STILLING BASIN DETAIL
NOT TO SCALE

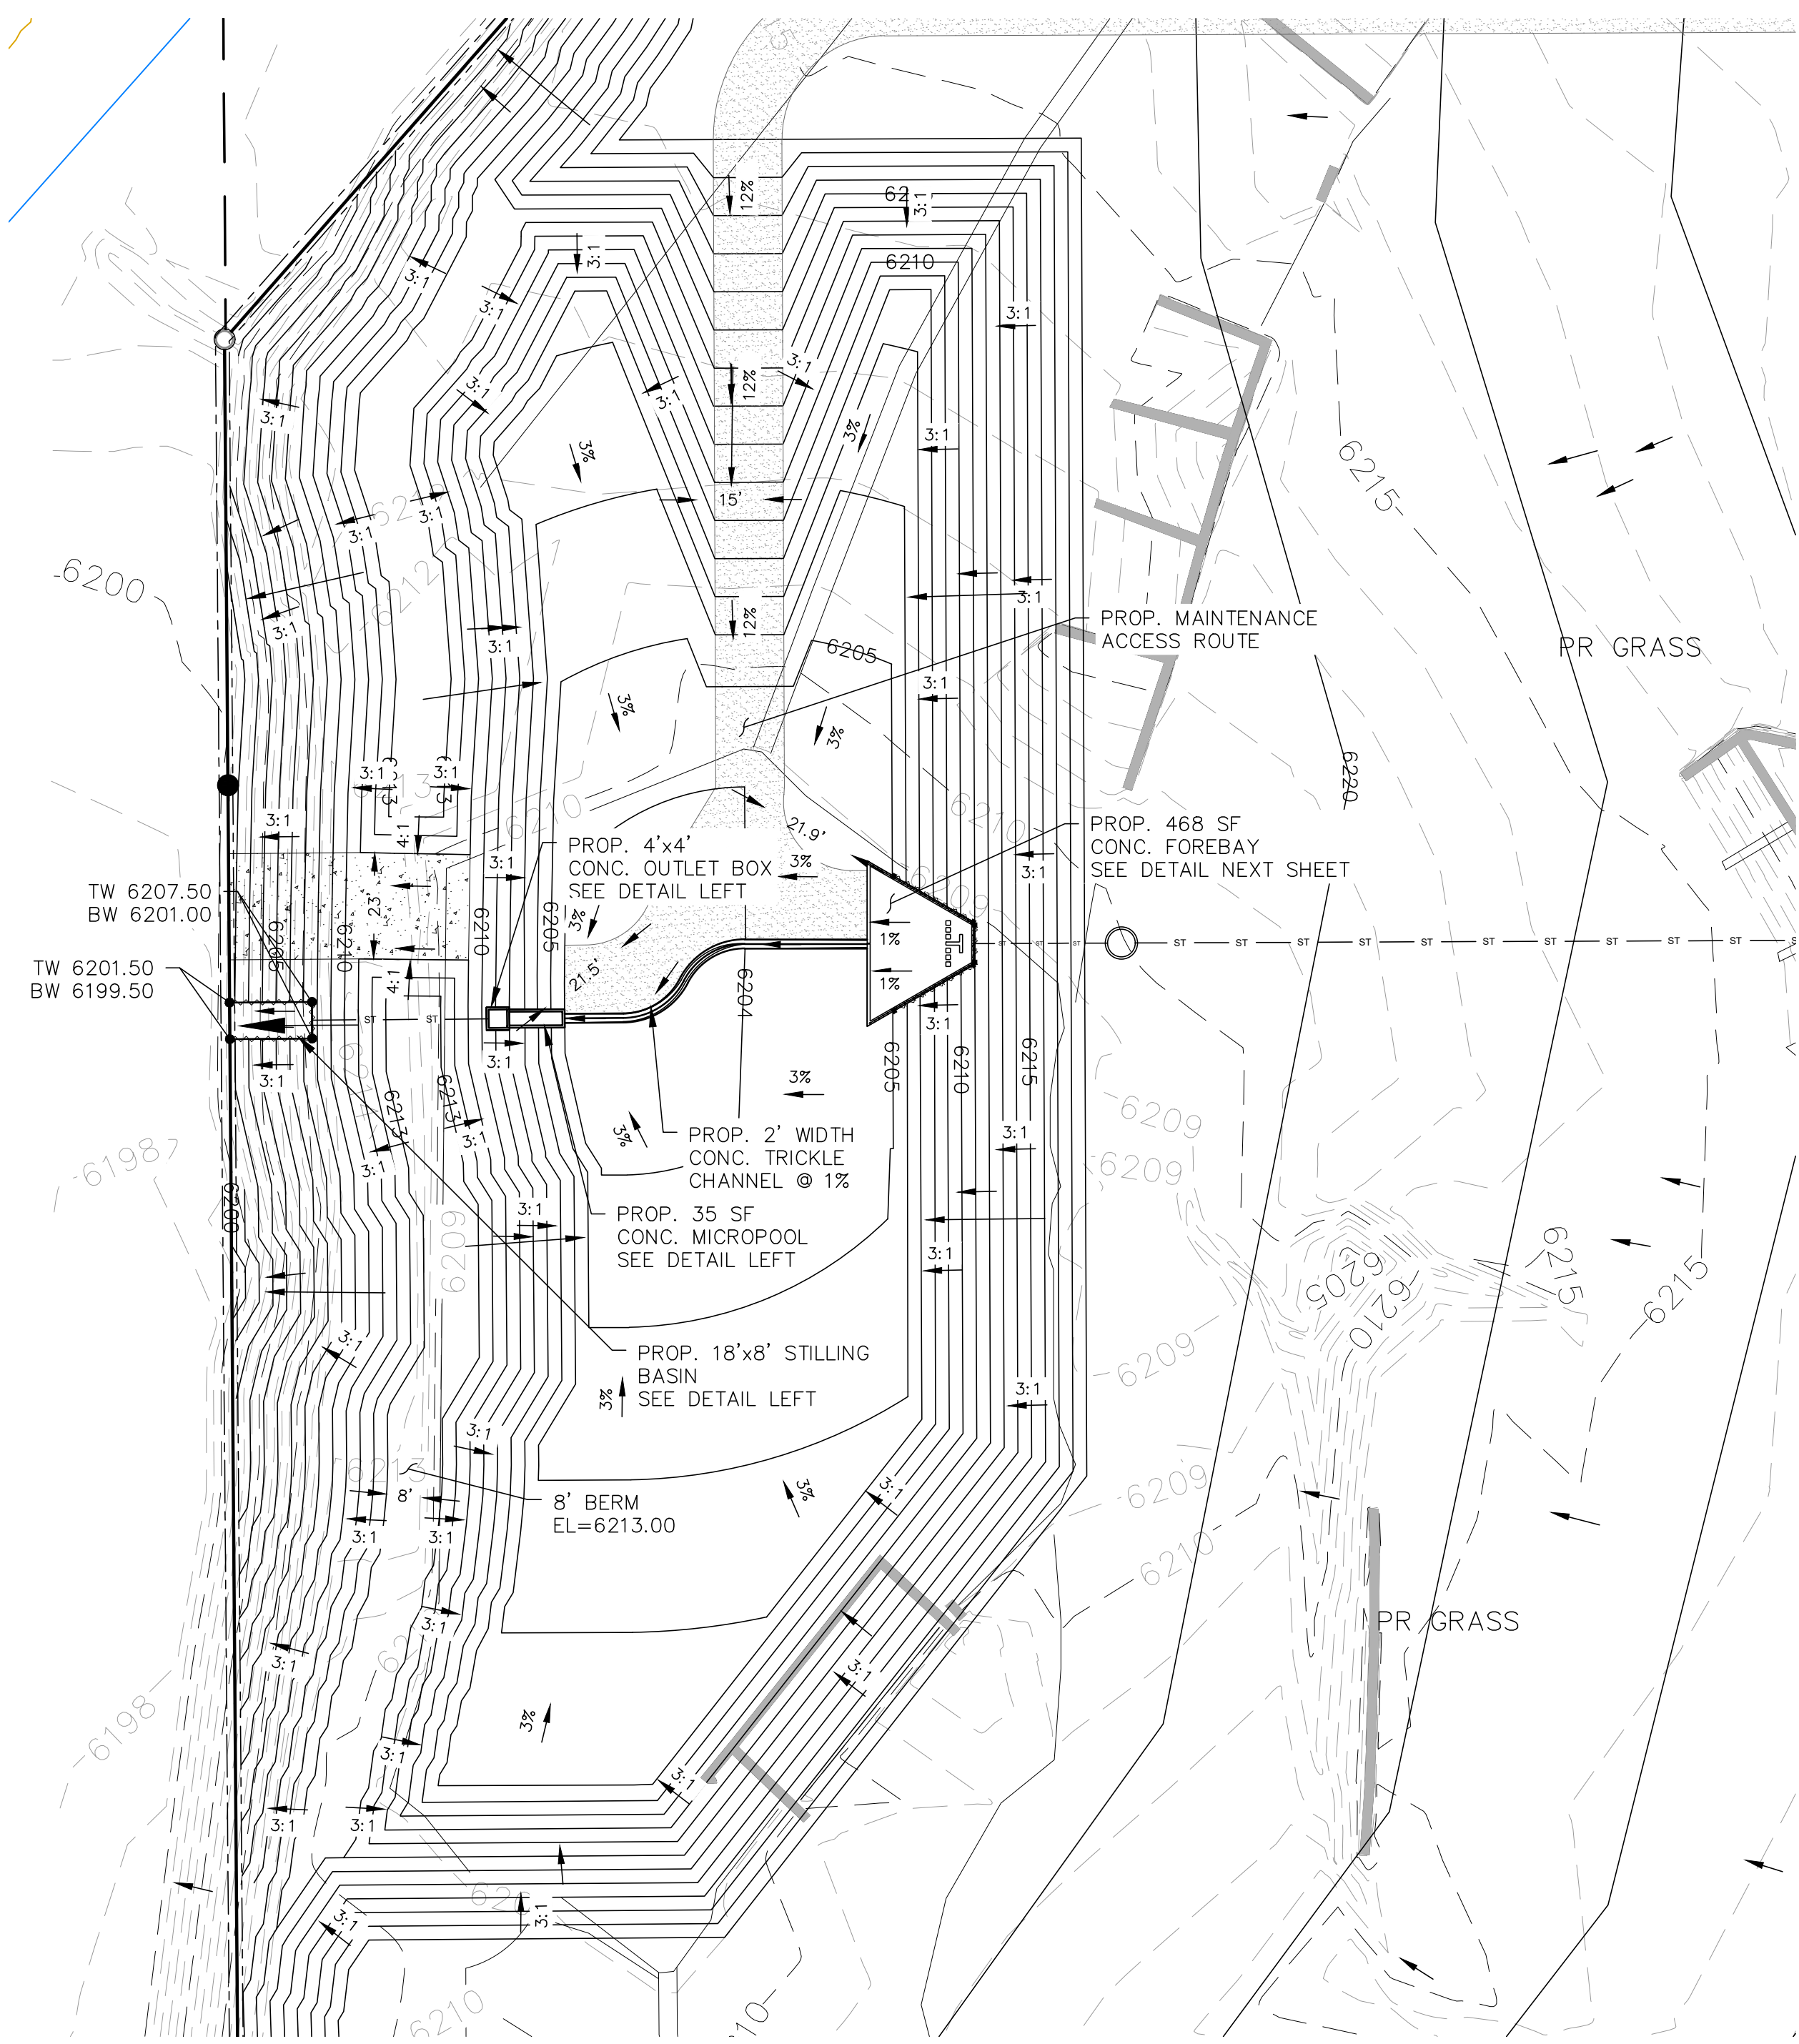
Please add decision about the stilling basin providing a suitable outfall. The comment response document addressed this point but that text was not incorporated into the report text.

*Include discussion of suitable outfall. Where do these flows go, does it handle flows, even if they are less, etc?*

Unresolved:  
Provide calculations in appendix  
for sizing of stilling basin

*added sentence about stilling basin*

*added sentence about outfall and noted that it follows historic path*

see appendix  
for calcs

PLATTE SELF STORAGE  
PROPOSED DRAINAGE MAP

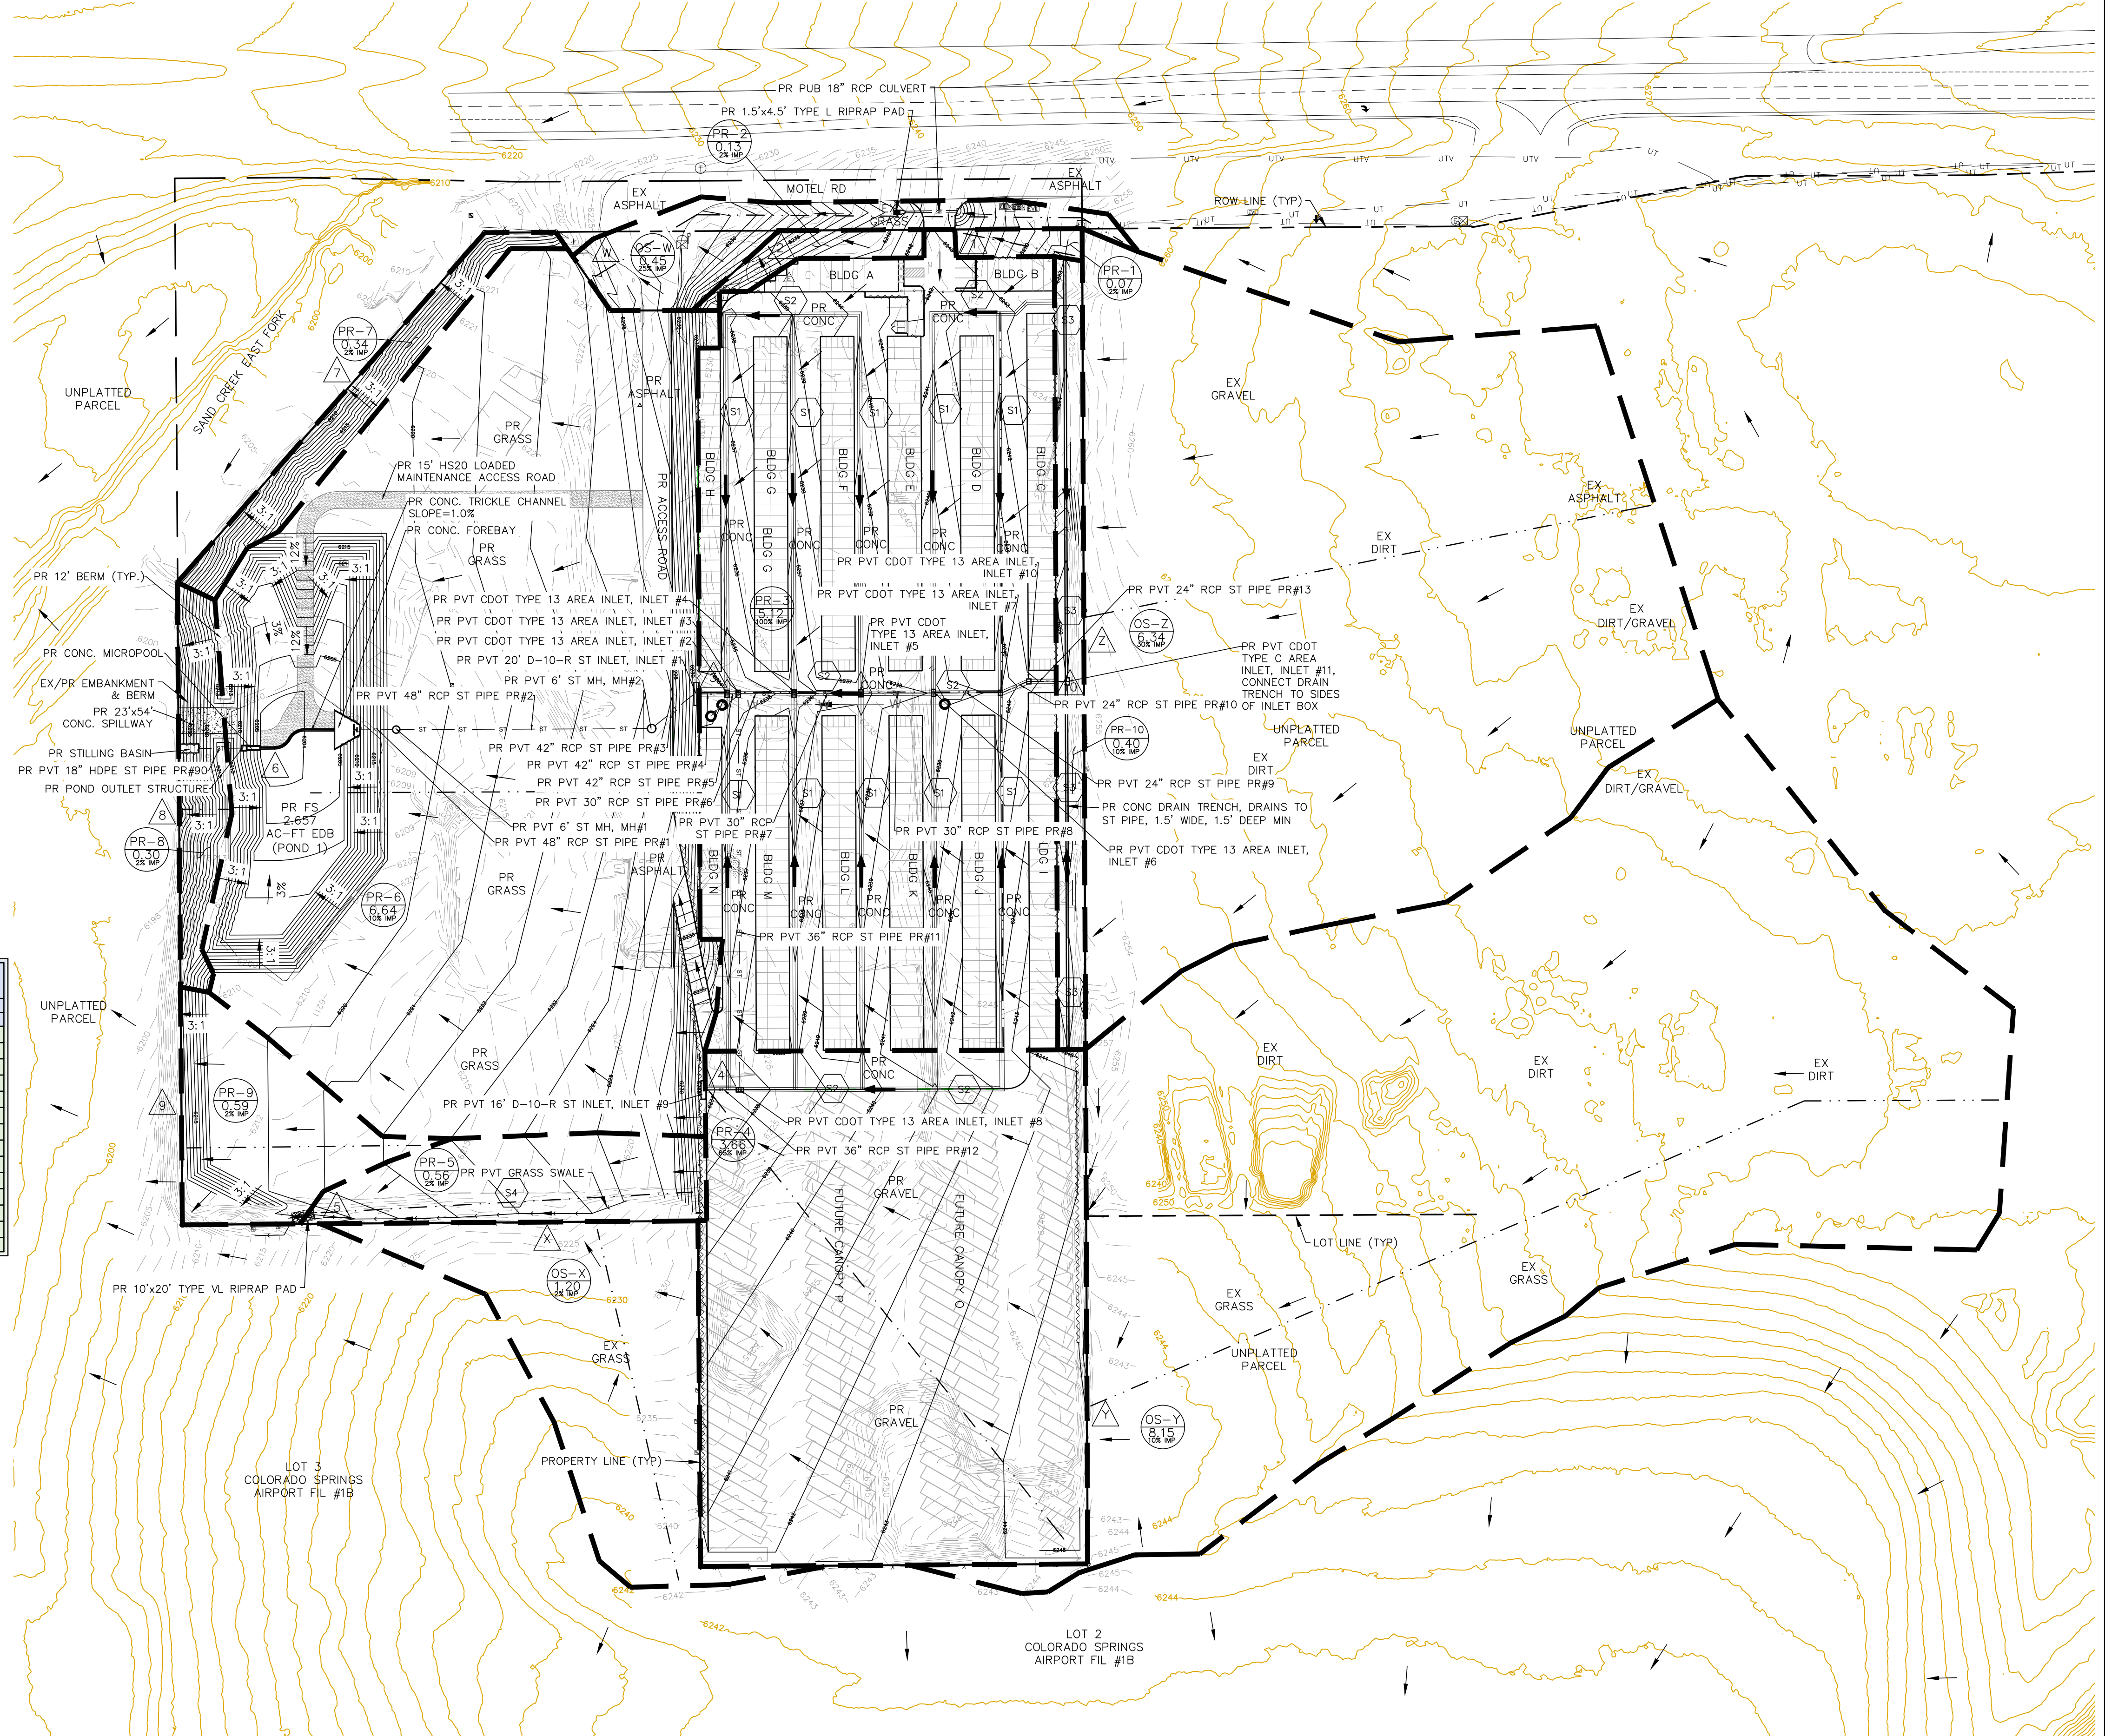
Please state if this proposed gravel yard will be treated by the pond. This currently provides multiple options for conveyance. Is the gravel yard a future development the pond is proposing to account for? If not and the gravel yard is proposed with this development it needs to be clear how the runoff will reach the Pond.

Unresolved:  
Please show & label all drainage easements.

We have shown  
a drain and access route for  
pond and road
